COMMUNITY DEVELOPMENT DEPARTMENT
501 Delta Avenue ♦ Marysville, WA 98270 ♦ (360) 363-8000

Re: PA23-026 – Cornelius Lacey PRD – Technical Review 1

After preliminary review of the above referenced proposal, the Planning Division has the following comments:

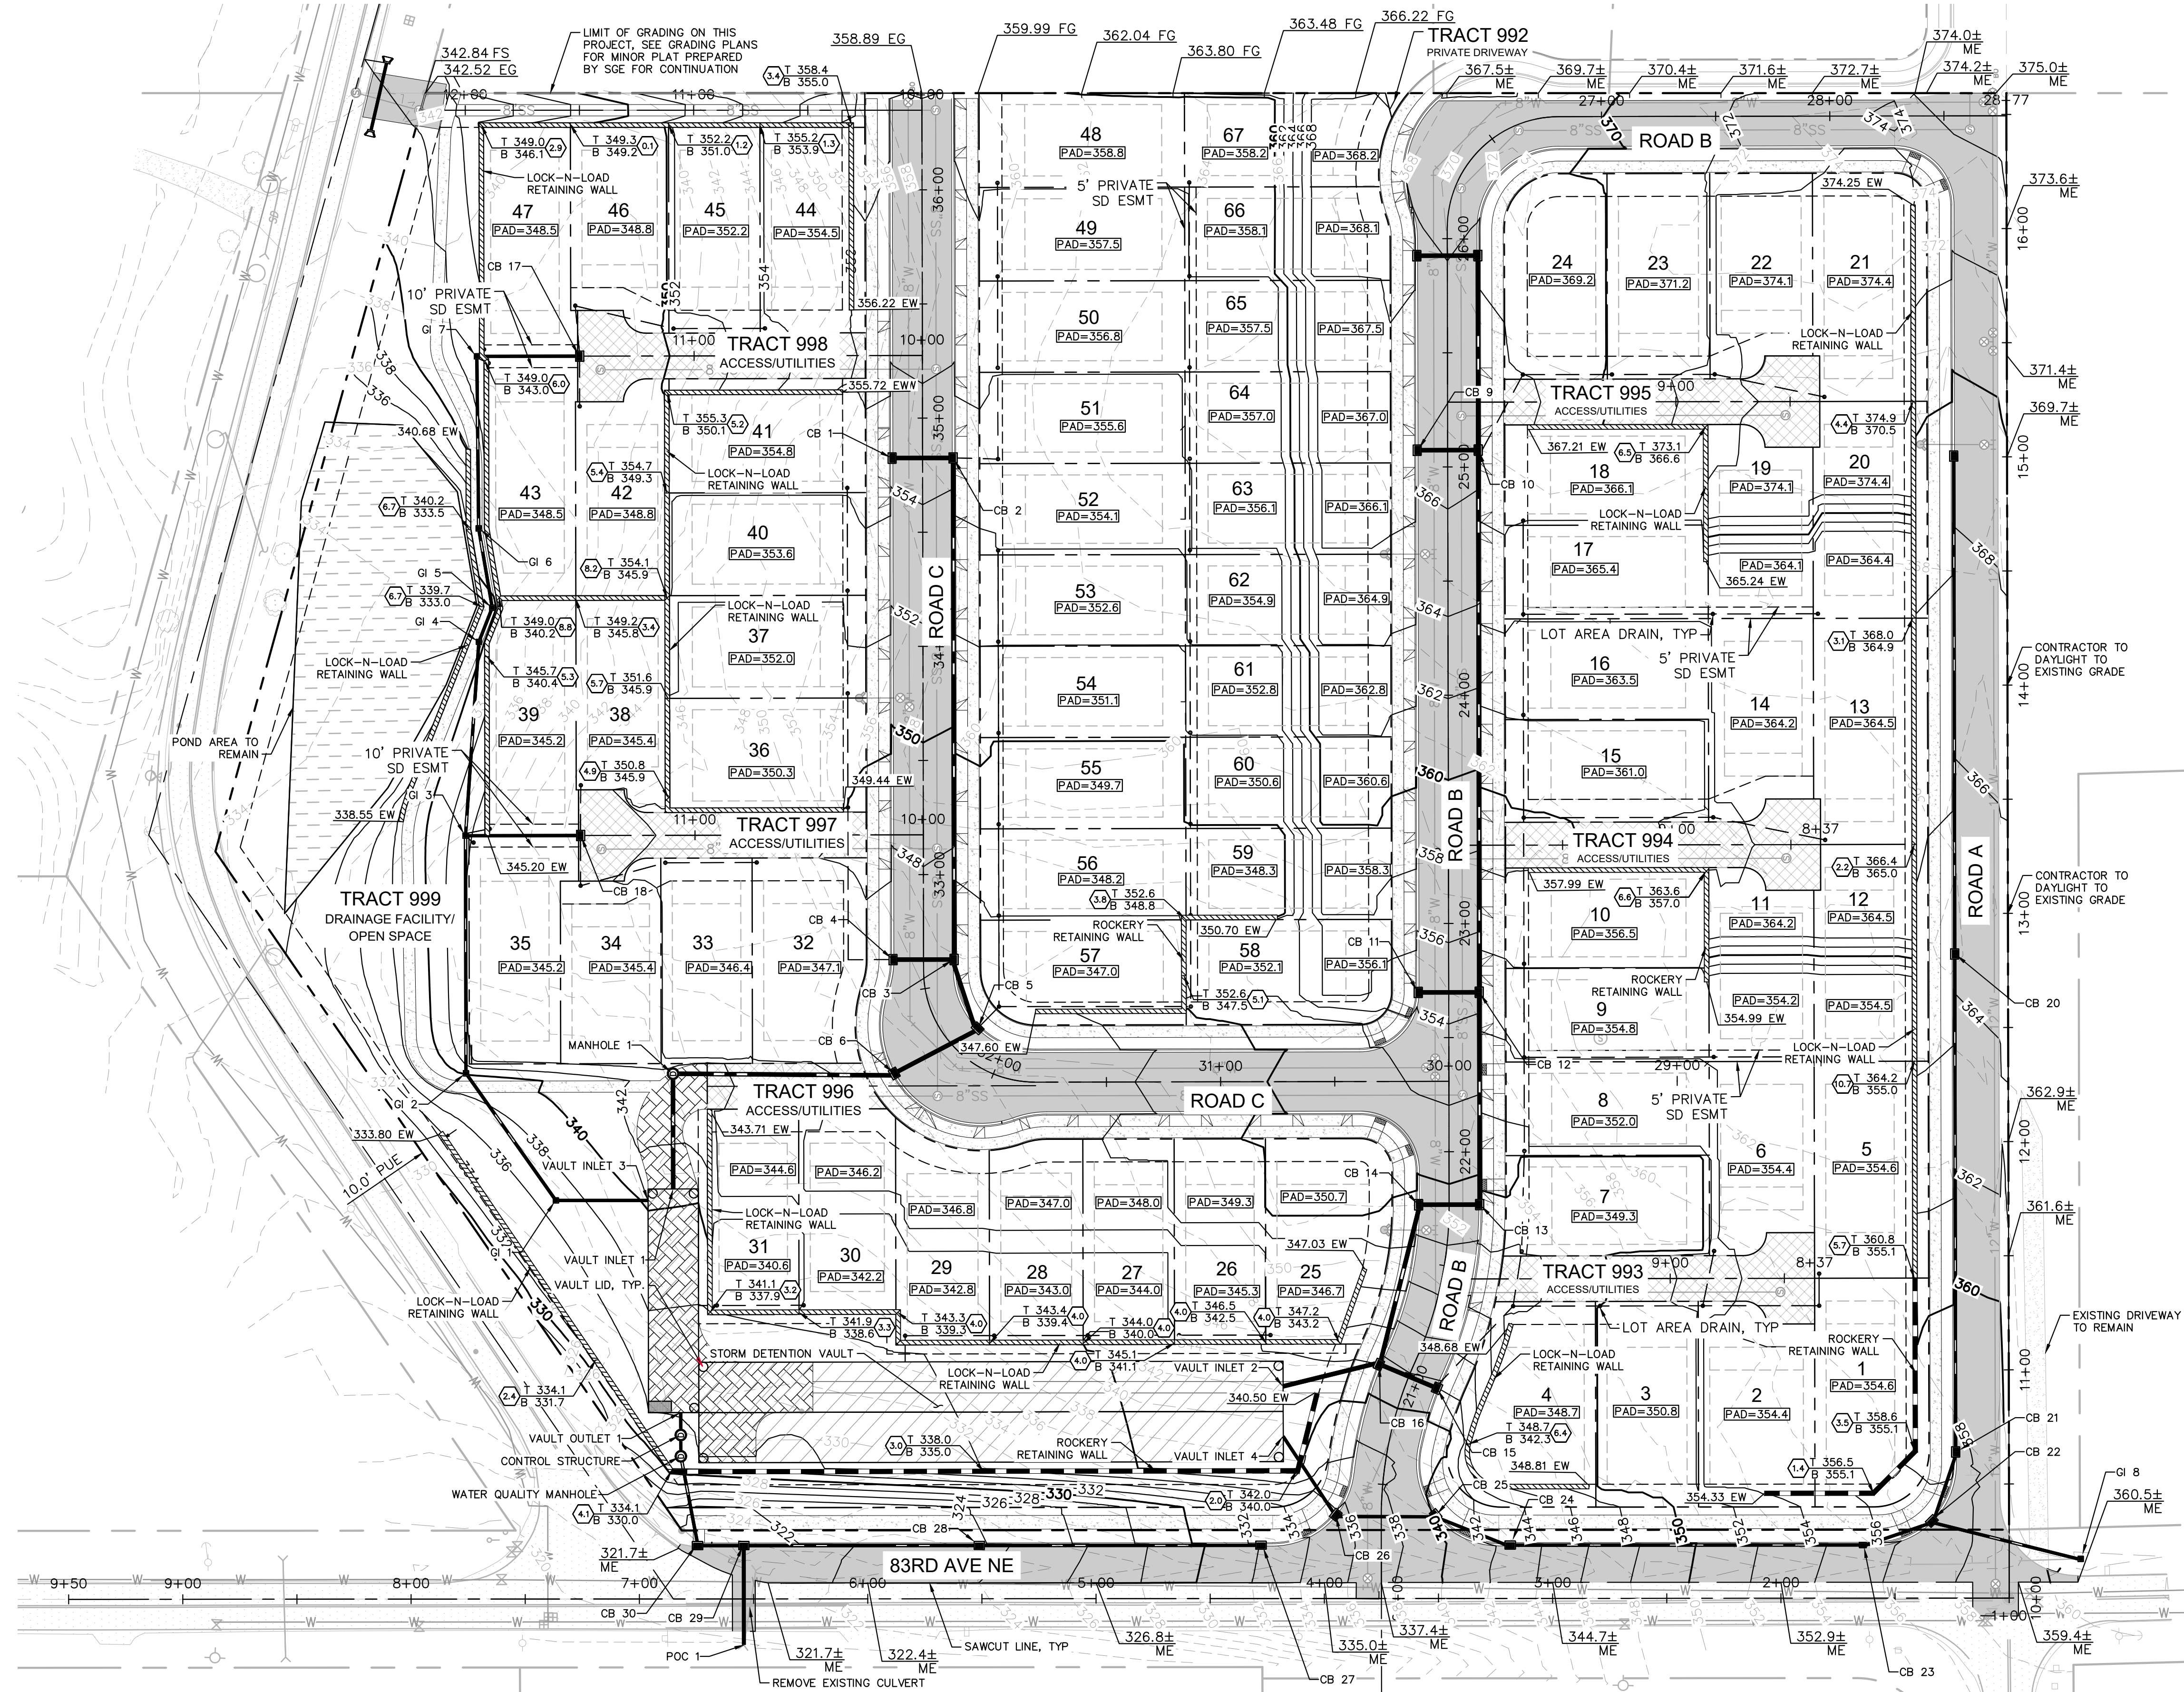
3. Trench restoration is to be completed in accordance with section 3-703 of the EDDS. A full lane or full street overlay may be required.
4. The onsite grading and placement of any retaining walls must be compliant with section 22D.050.030 of the MMC.

DRAWING TITLE:
LANDSCAPE PLAN
APPLICANT:
KM CAPITAL, LLC
C/O LAND PRO GROUP INC.
10515 20TH STREET SE, SUITE 202
LAKE STEVENS, WA 98258
(425) 231-2718

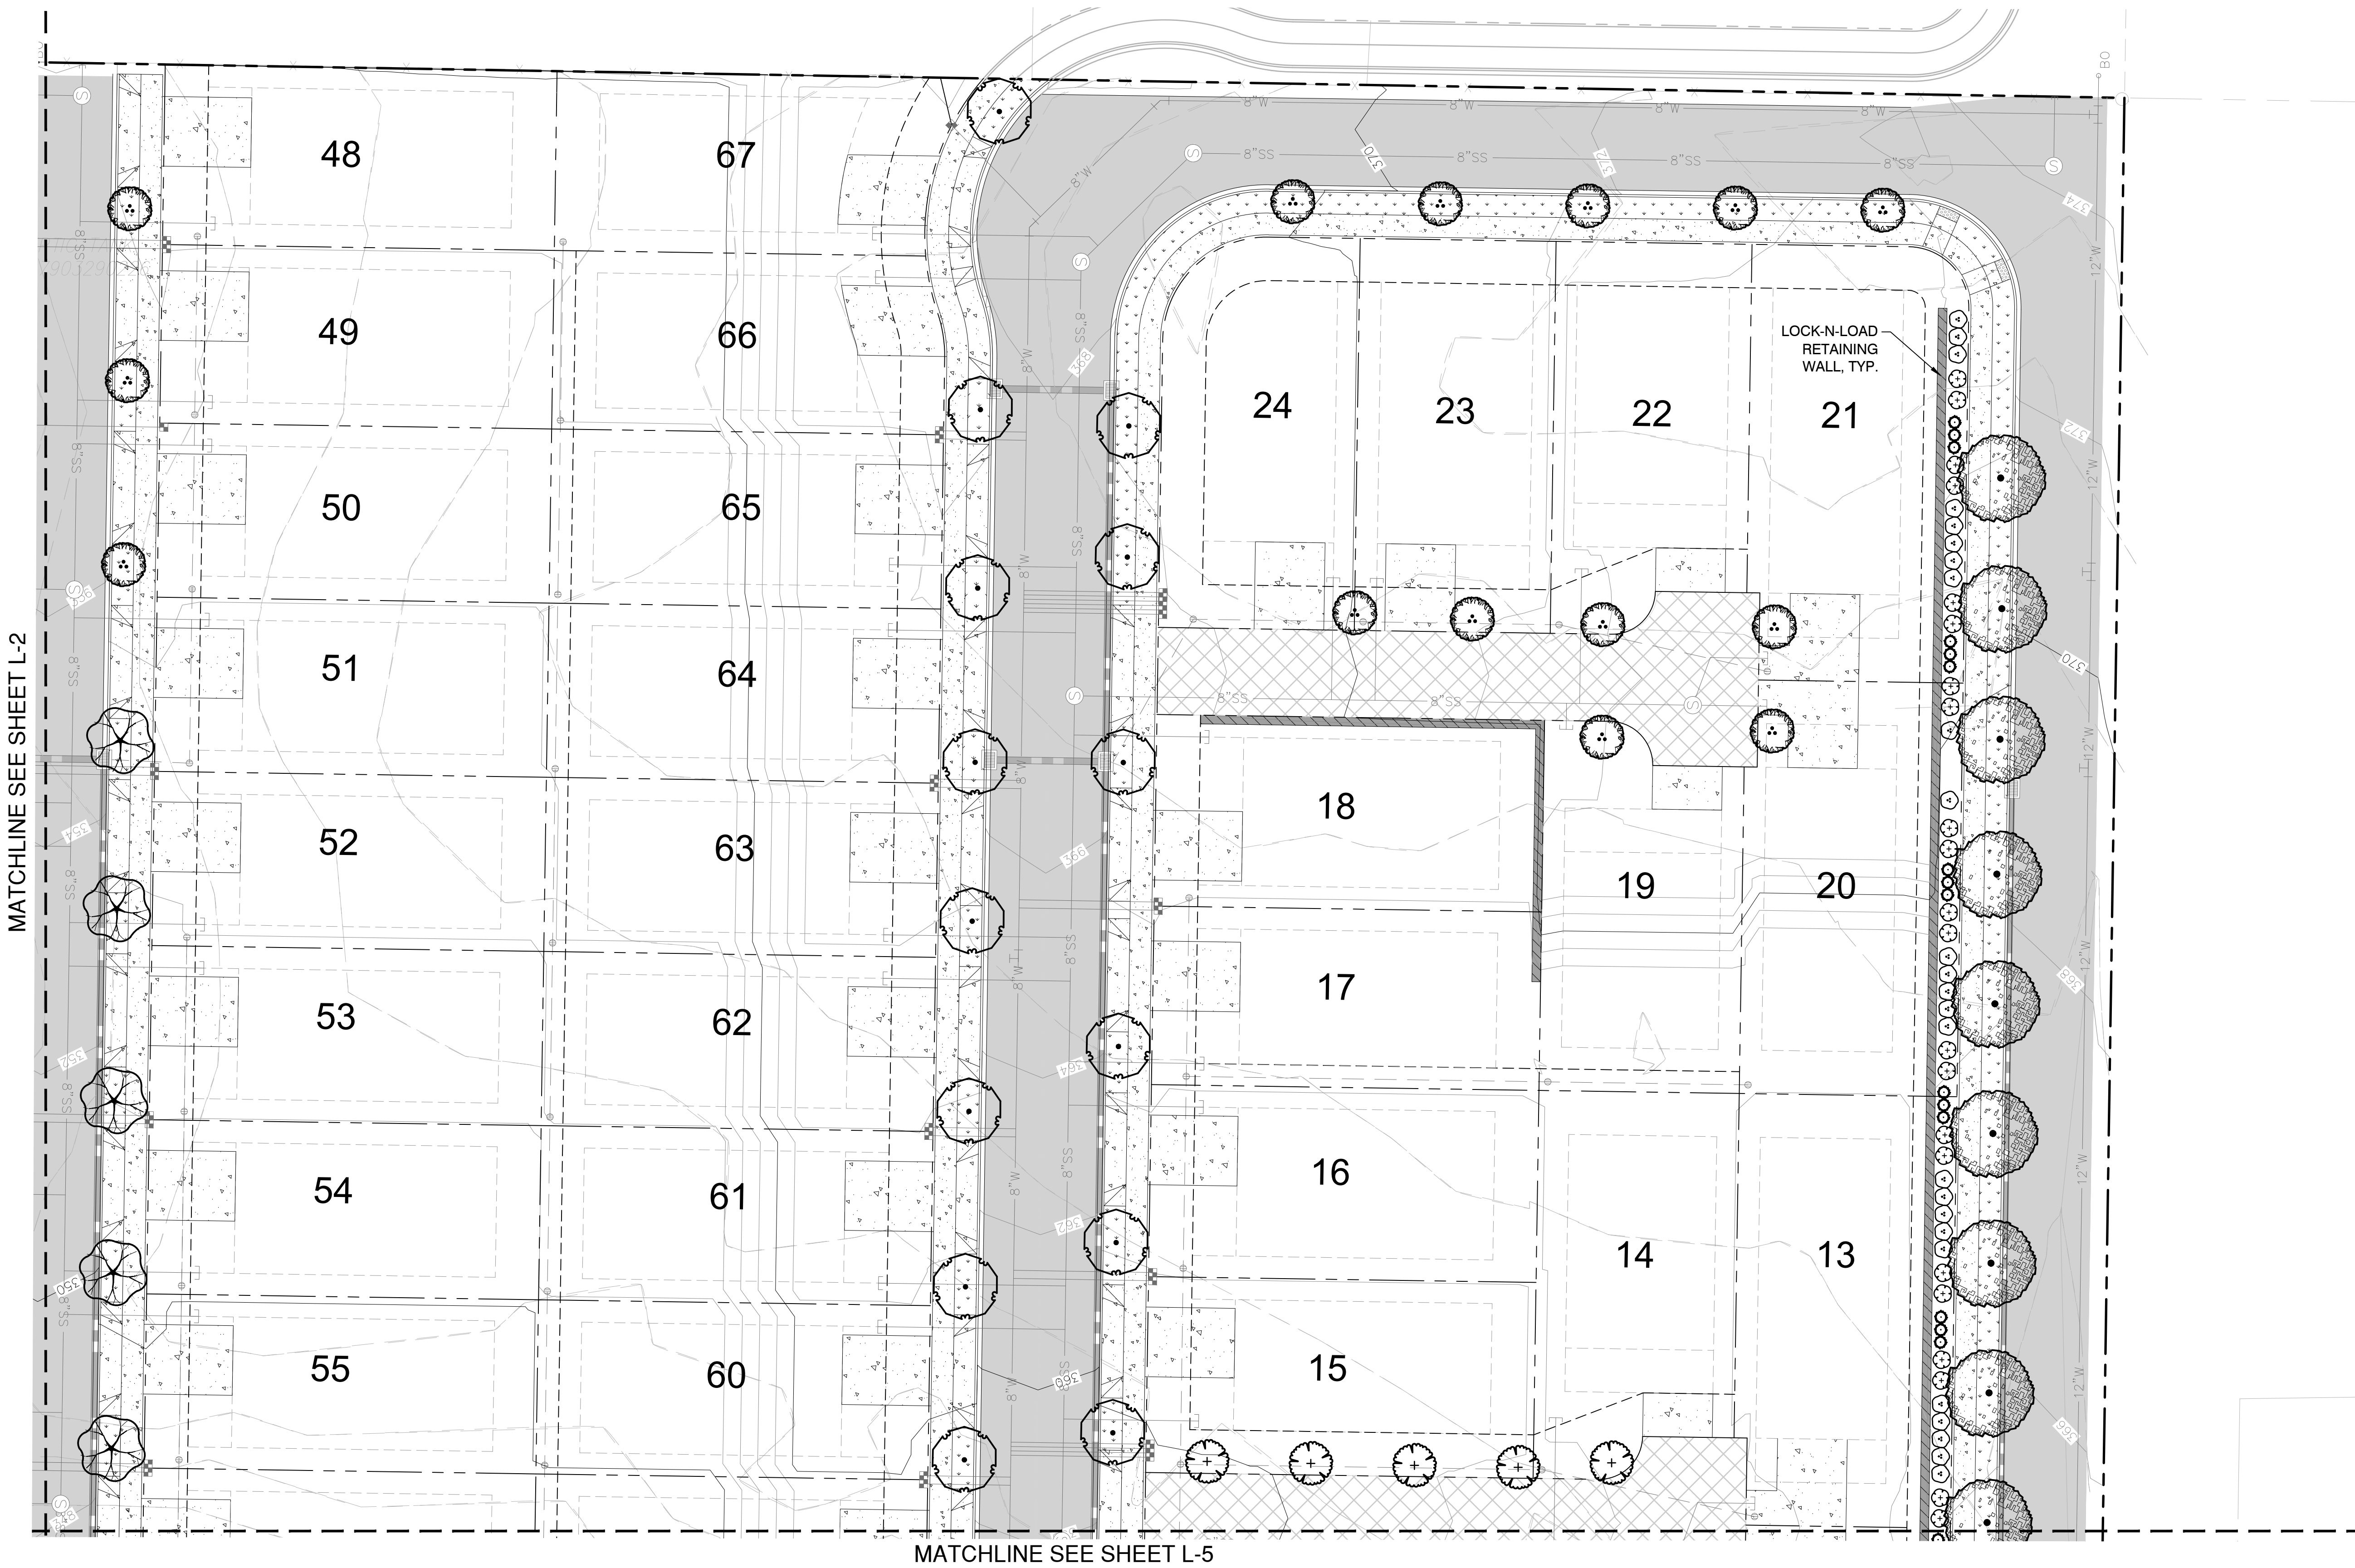
- . The maximum height of solid (more than 50% opaque) freestanding walls, fences, or hedges in any front yard or other location between the street and the façade shall be 3-1/2 feet unless a taller wall is required, per the Director, to mitigate significant noise and traffic impacts. ***This will be applied to all lots adjacent to Road A (44th Street), 83rd Avenue NE, as well as lots interior to the project.***

- . In development configurations where side yards abut a street, fences taller than 3-1/2 feet shall be setback at least 5 feet from the sidewalk to allow for landscaping to soften the view of the fence. Provisions for long-term maintenance of this landscaping shall be addressed on the plat. ***This will be applied to all lots adjacent to Road A (44th Street) and applicable interior lots. Landscape plans shall be revised prior to civil construction plan approval.***

9. A final landscape plan shall be required to be approved, prior to civil construction plan approval, and designed to comply with the applicable provisions outlined in [MMC Chapter 22C.120, Landscaping and Screening](#).
 - 9.1. Location of precast vault lids need to be shown as well as proposed access to said lids.
 - 9.2. Ensure compliance with the fencing/screening standards of [East Sunnyside Whiskey Ridge Design Standards](#).
10. All stormwater management facilities, including vaults, are required to be screened with a 5-foot type L1 buffer.
